Re: ABP case reference : 324258

Applicant : Constant Energy Limited_Tirawley wind farm

In ABP case reference **324258** to which this observation refers, the applicant has, as one can see in Map 1, next page, ignored the turbine separation distances from adjacent turbines, that are recommended in the WEDG2006 guidelines.

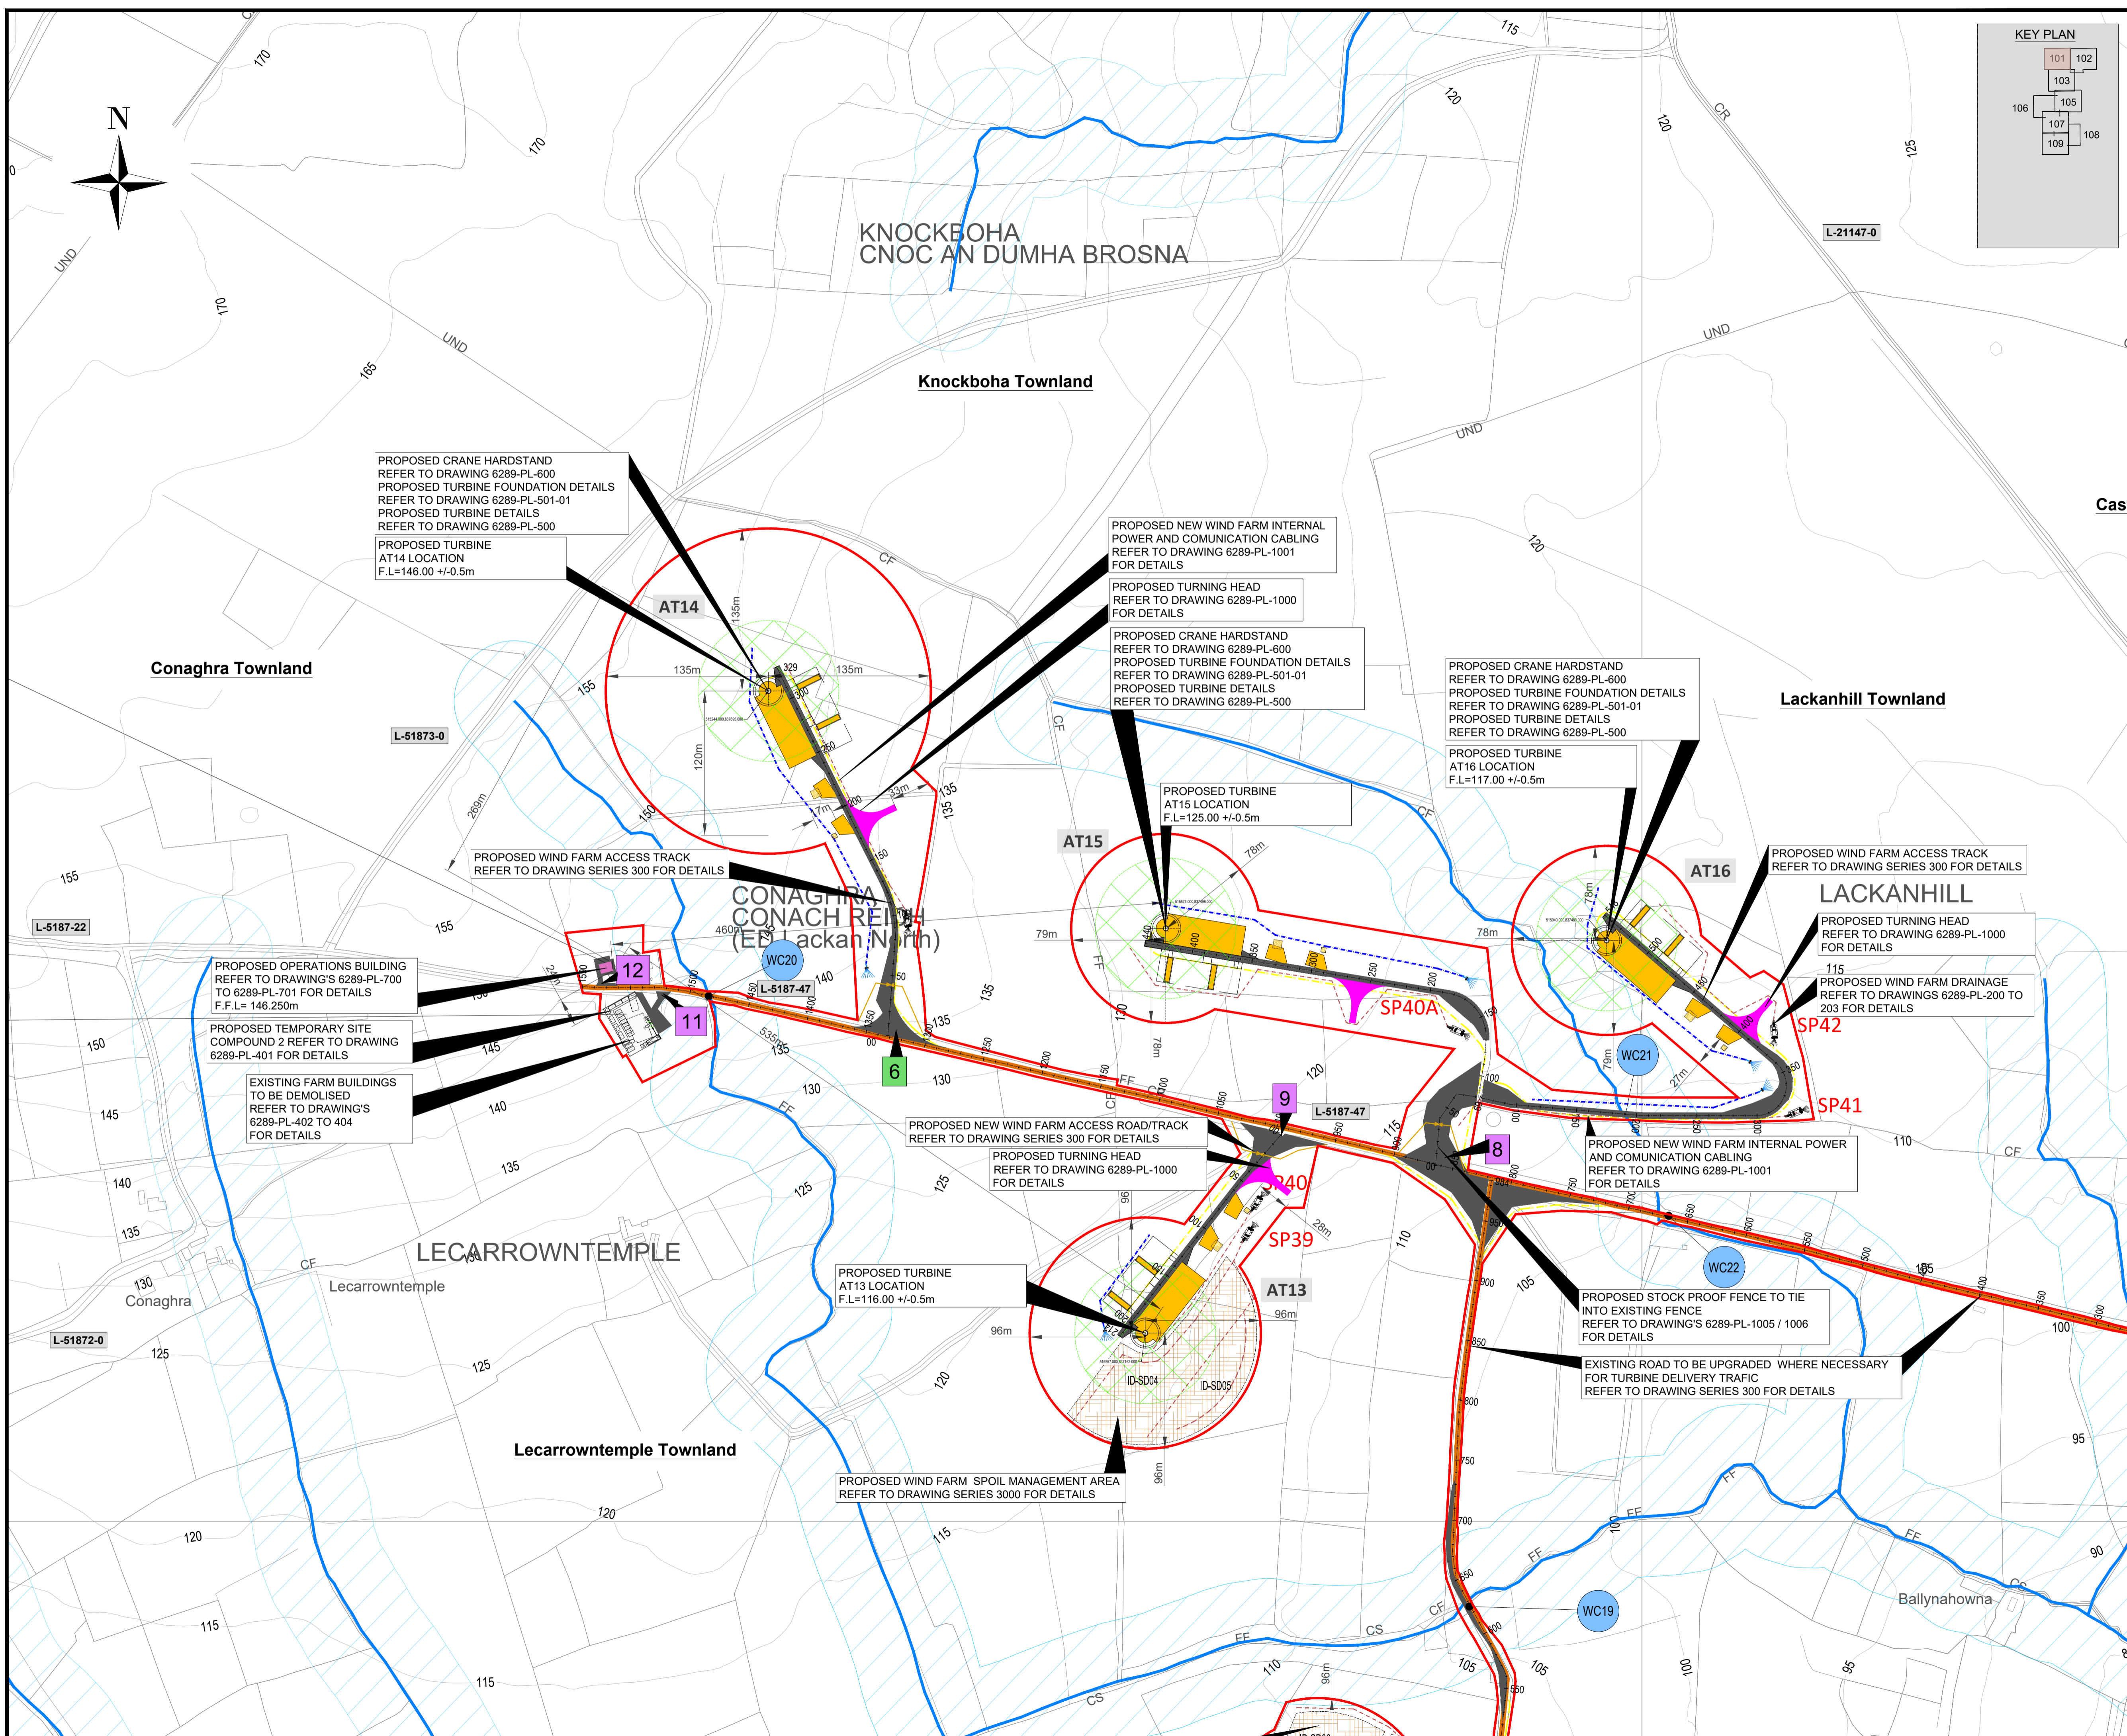
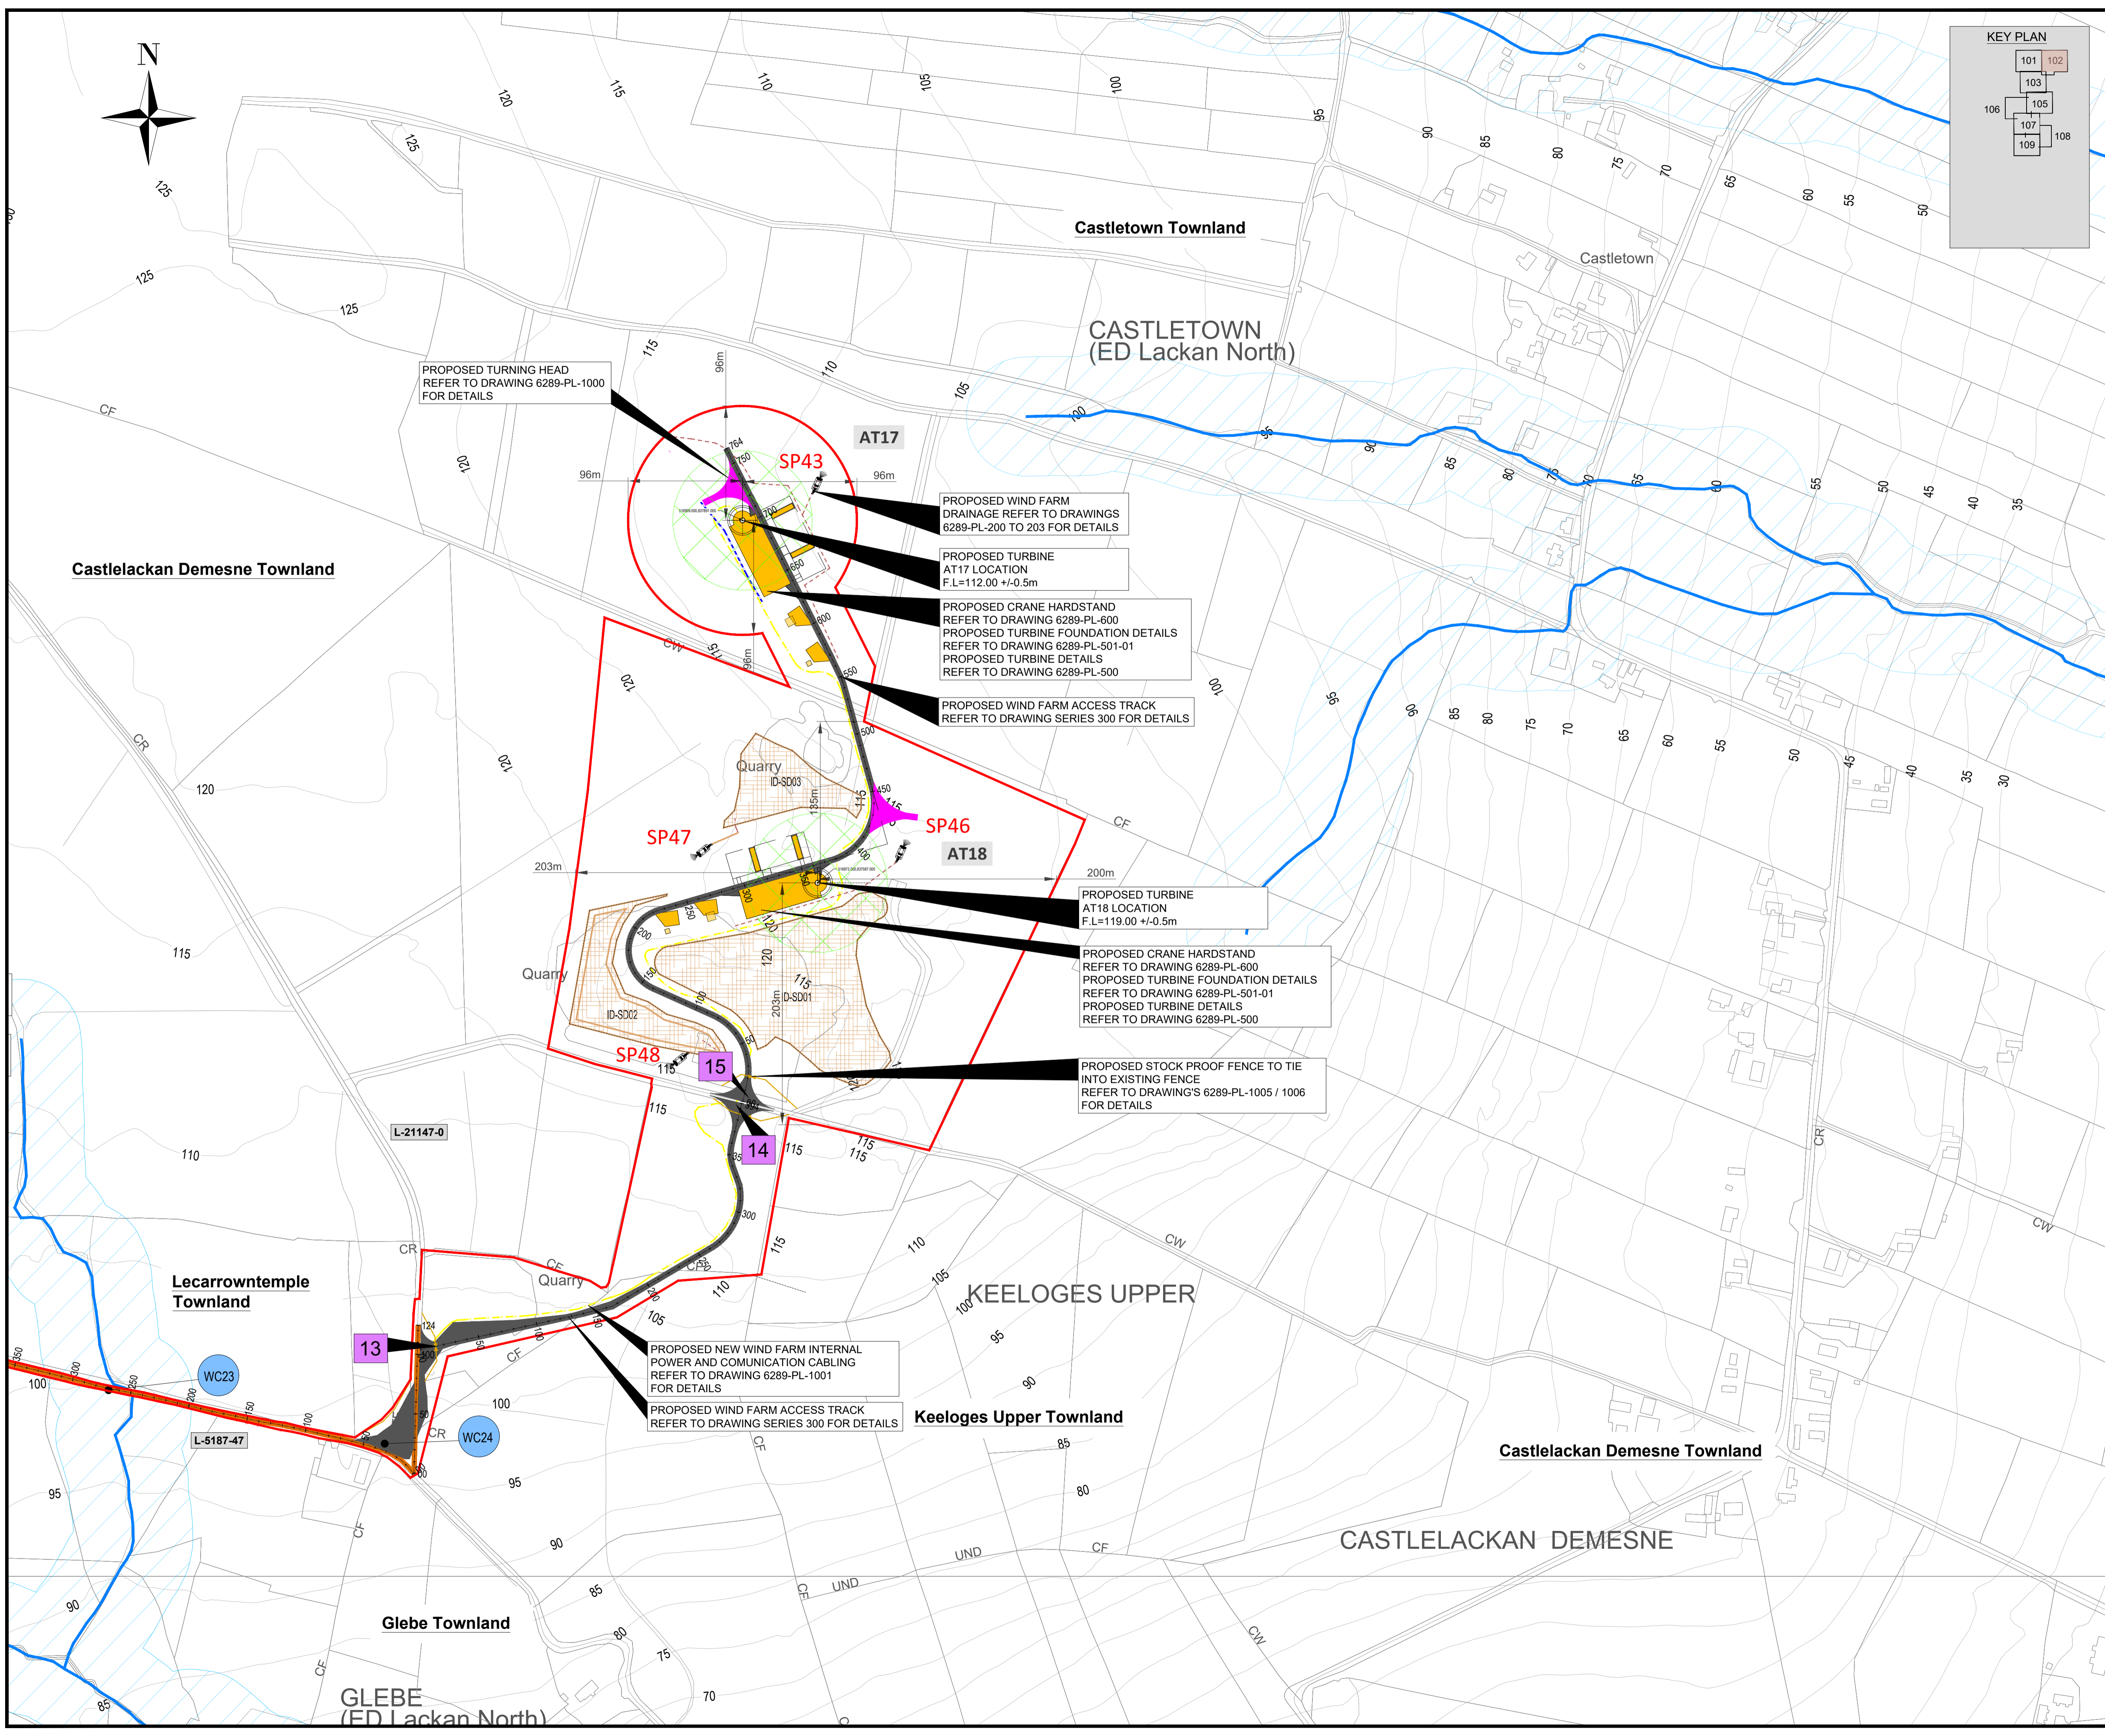
AT3 to AT4 has only 2.86 rotor diameters instead of 7 rotor diameters. 41% of required separation
AT6 to AT5 has only 2.34 rotor diameters instead of 7 rotor diameters. 33% of required separation
AT7 to AT8 has only 2.43 rotor diameters instead of 7 rotor diameters. 35% of required separation
AT9 to AT10 has only 2.38 rotor diameters instead of 7 rotor diameters. 34% of required separation
AT11 to AT13 has only 2.87 rotor diameters instead of 7 rotor diameters. 41% of required separation
AT13 to AT14 has only 3.13 rotor diameters instead of 7 rotor diameters. 45% of required separation
AT11 to AT14 has only 4.30 rotor diameters instead of 7 rotor diameters. 61 % of required separation

I would also include AT2 to AT3, AT10 to AT11, AT15 to AT16 & AT12 to AT13 in those 7 rotor diameter separation requirement as they have not a much lesser prevailing winds from the South Southeast and the West northwest directions.

On the basis of what I have outlined and experienced, I highly recommend the aforementioned issues be carefully considered, and the design be altered significantly.
